To: All Staff
From: Environmental Health
Date: September 9, 2025
Subject: SX-25-00010 GOTT

SCALE
 □ = 10 FT

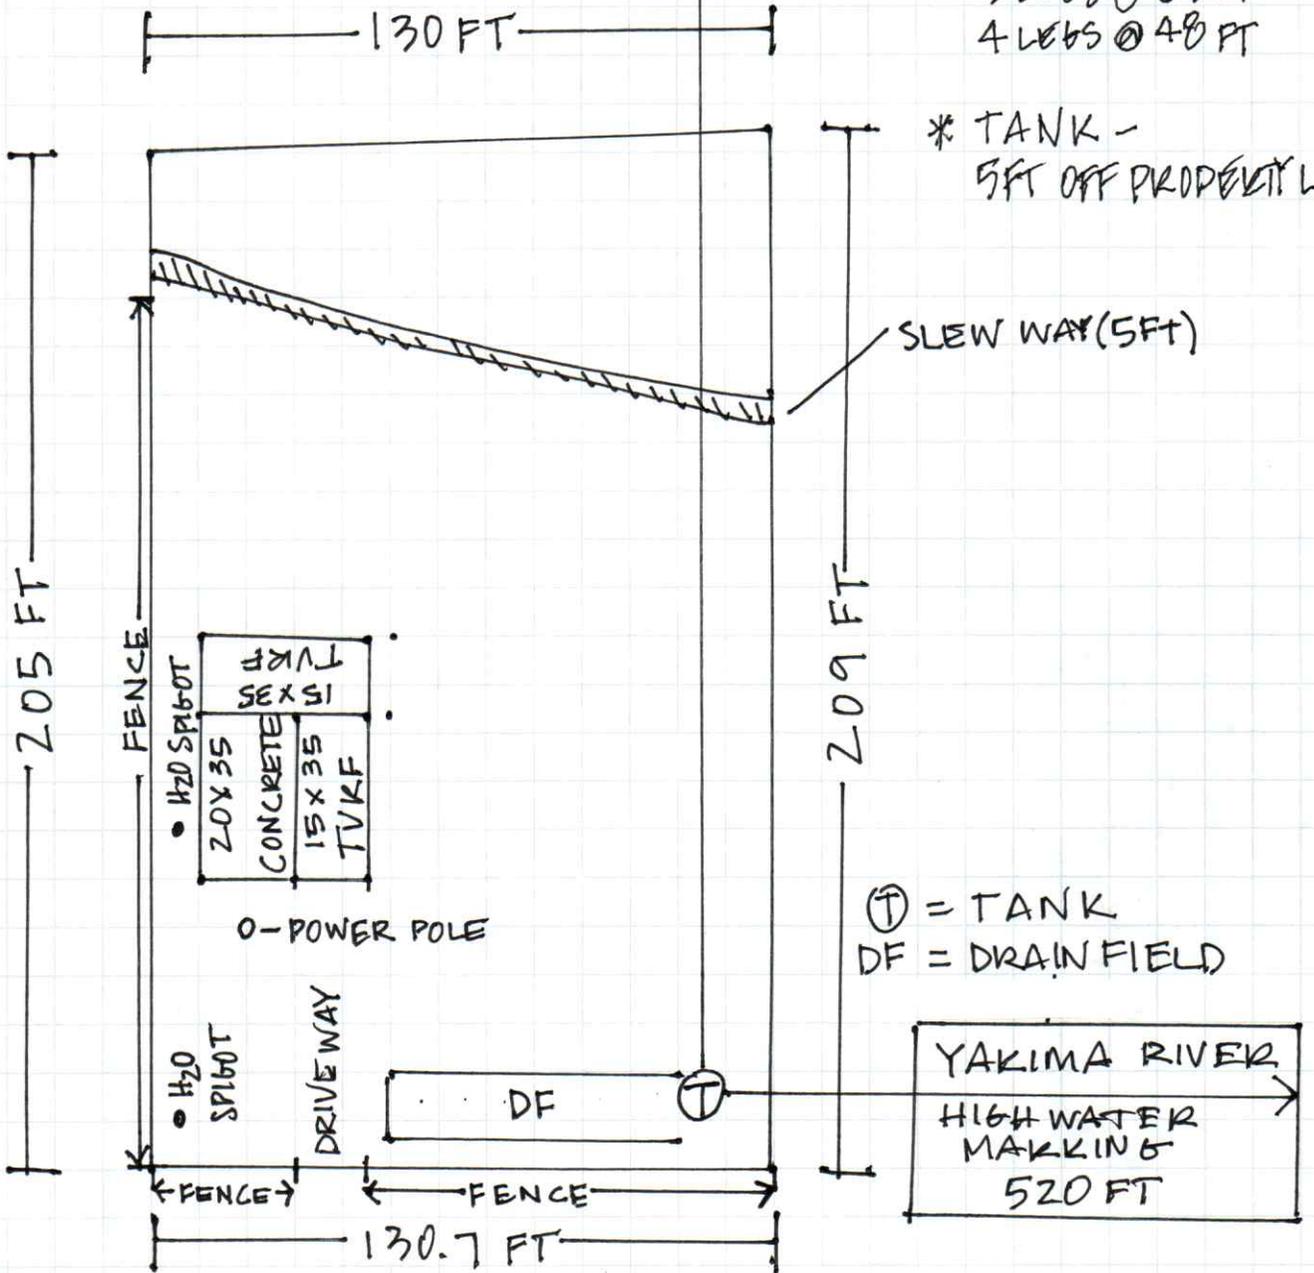
Drinking Water	<ul style="list-style-type: none">• N/A
Wastewater	<ul style="list-style-type: none">• Maintain 100ft setbacks from any surface water. If unable to a waiver may need to be completed.
